CITY OF ALBUQUERQUE

January 10, 2022

**RE: ABCWUA Distribution Fill Soils Yard
5408 2nd St. NW
Grading and Drainage Plan
Engineer's Stamp Date: 12/07/2021
Hydrology File: F15D056**

Based upon the information provided in your submittal received 12/7/2021, the Grading & Drainage Plan is **not** approved for Grading Permit or paving permit. The following comments need to be addressed for approval of the above referenced project:

SHEET C-2

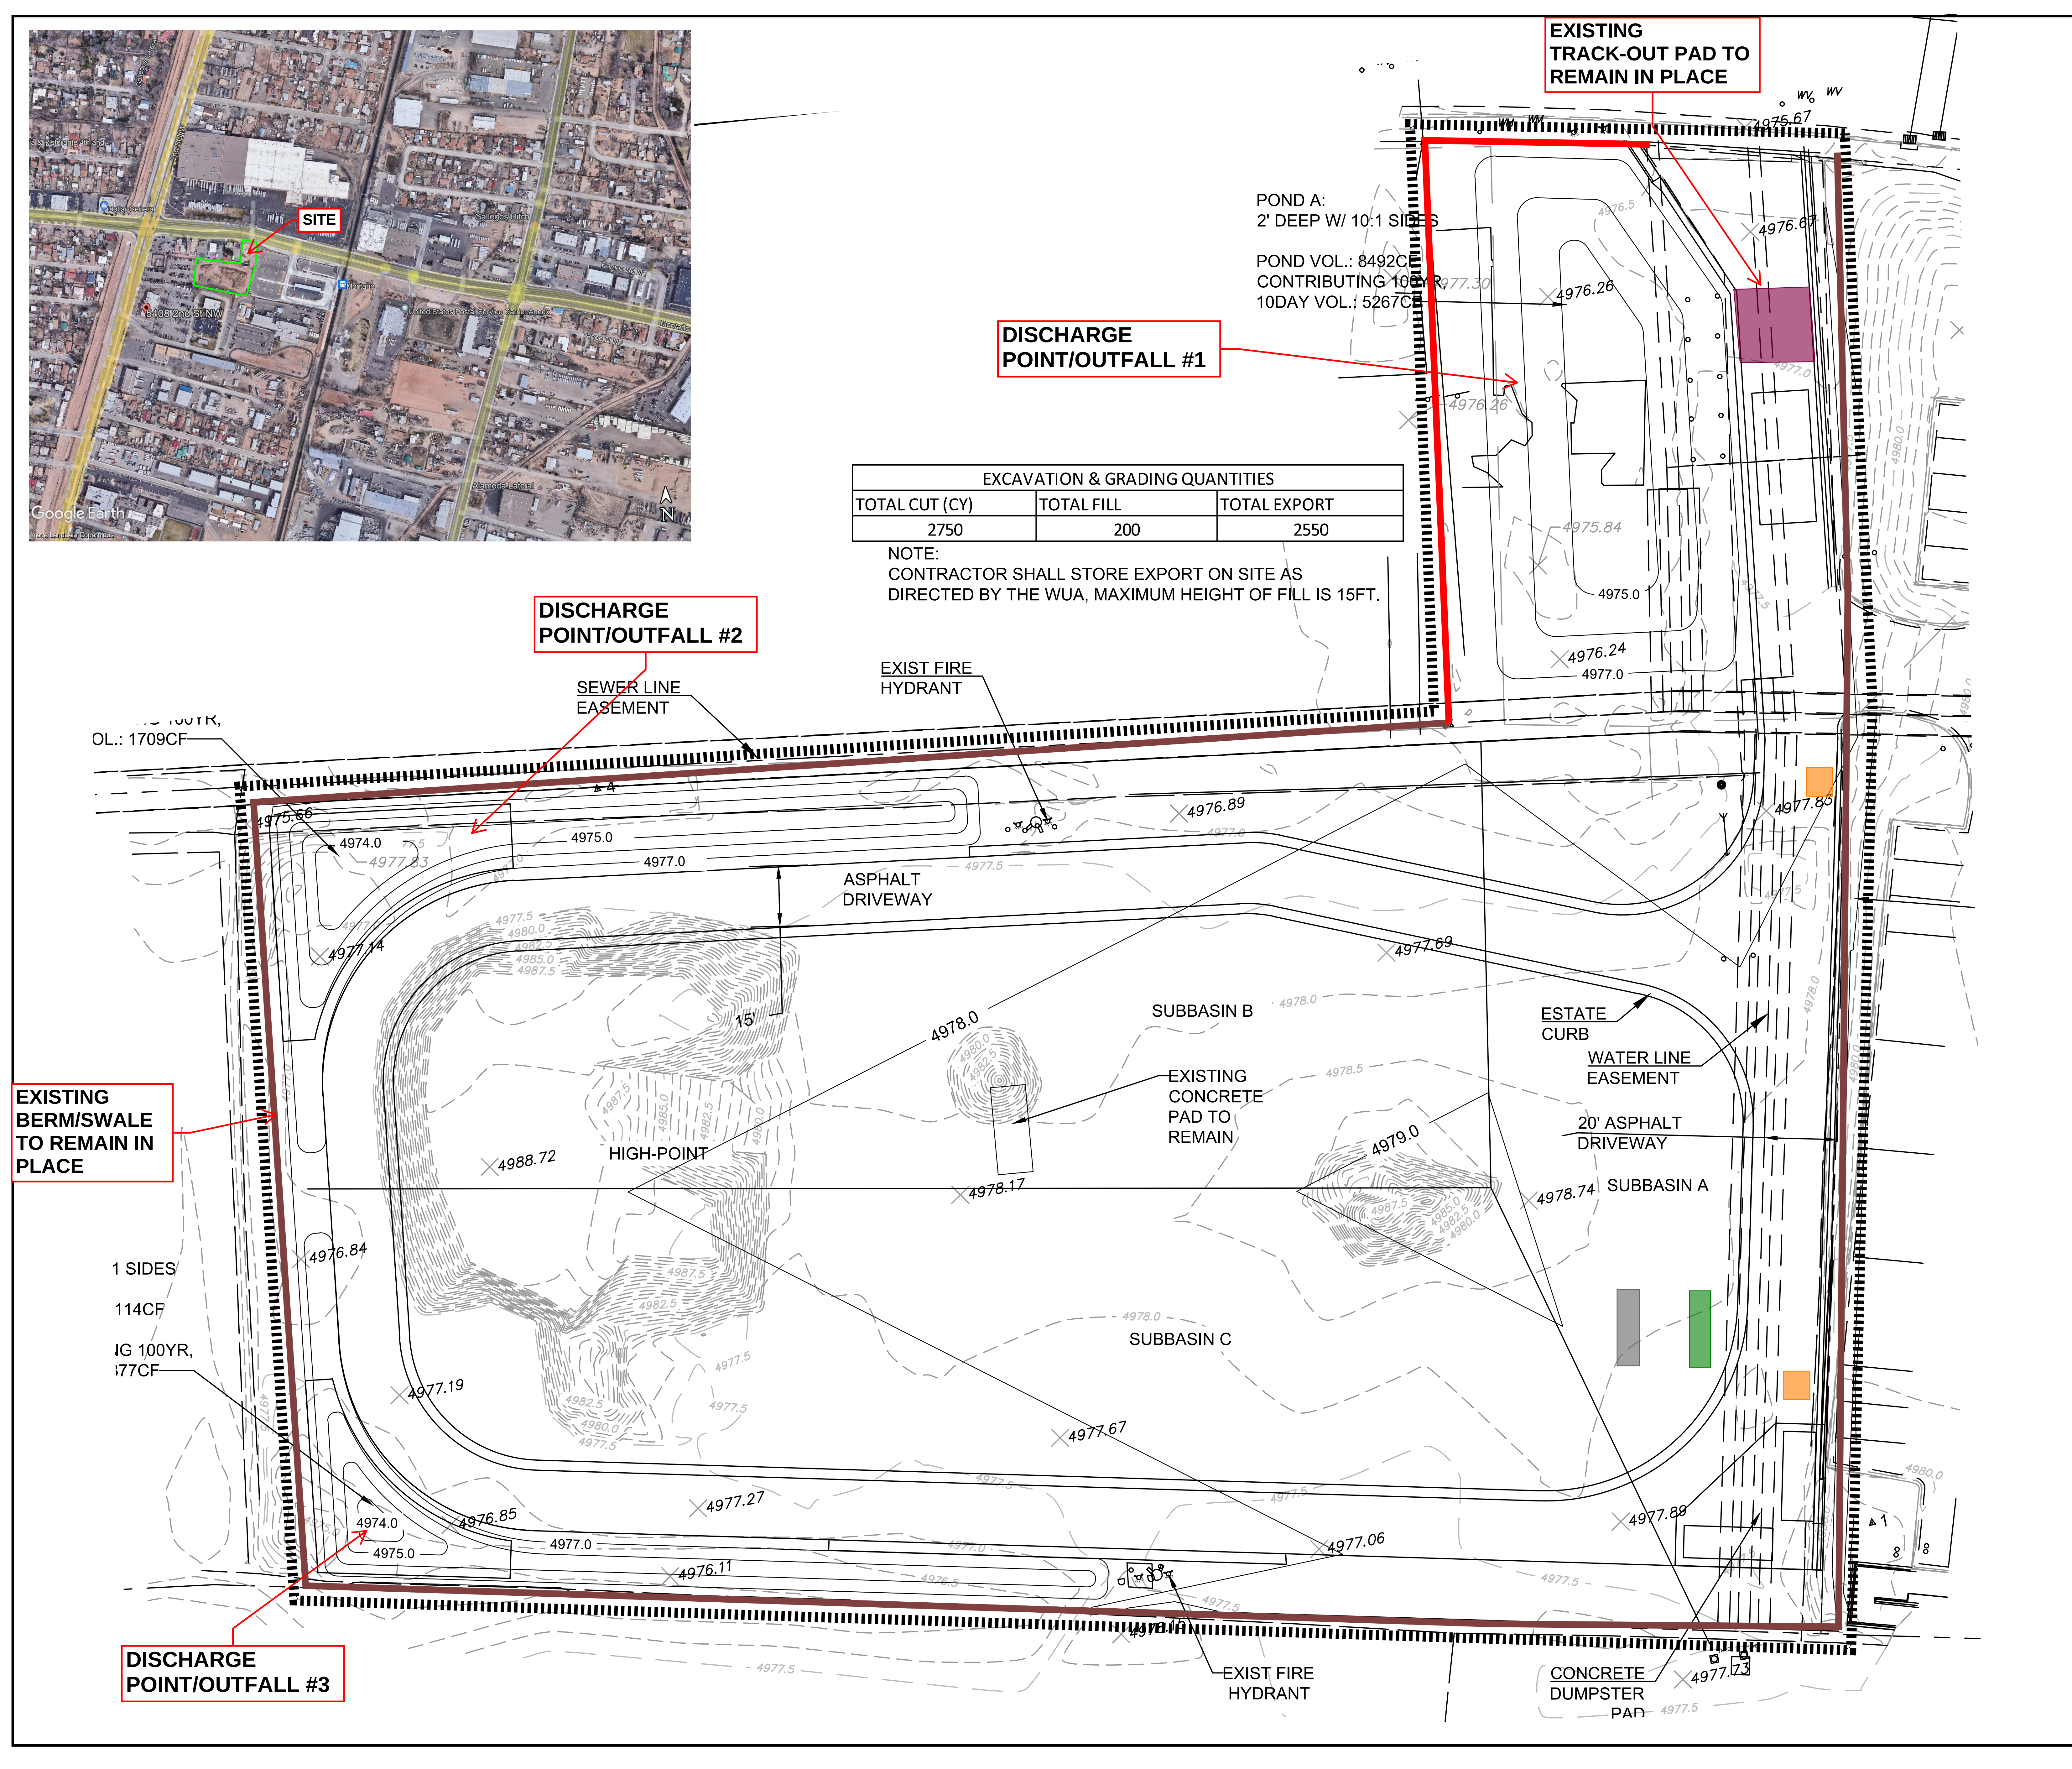
1. Please clearly label proposed vs. existing. It appears the internal driveway is being constructed but please note “proposed” for each item if it is proposed and “existing” if it is existing.

2. Please provide flow line elevations along roadway.
3. Please include a legend on the plan.
4. Please provide a basin map.
 - a. This will need to include the lot to the west if drainage is going to drain to that lot in any event.

- b. Provide 2 ft contours at least for the adjacent lot.
5. Please include the following note on the plans.
 - a. Please add a note under Grading Notes. “Side slopes need to be stabilized with Native Grass Seed (per City Spec 1012) with Aggregate Mulch or equal (Must satisfy the “Final Stabilization criteria” CGP 2.2.14.b.)”.

6. It is unclear what the badging stand is. Is it pertinent to the G&D? Is it a structure with a roof? If so where will they drain to?
7. Please provide section of the ponds.

- a. Within the section, please provide elevations of water and elevation of the top of pond.
 - b. Please provide spillway structure detail (can be with cross section).

- c. There is enough volume on the site to provide retention via all ponds with some small adjustments to the sites and basins.

- d. Calling them all retention ponds they need to account for the 10-day storm. Please clarify.
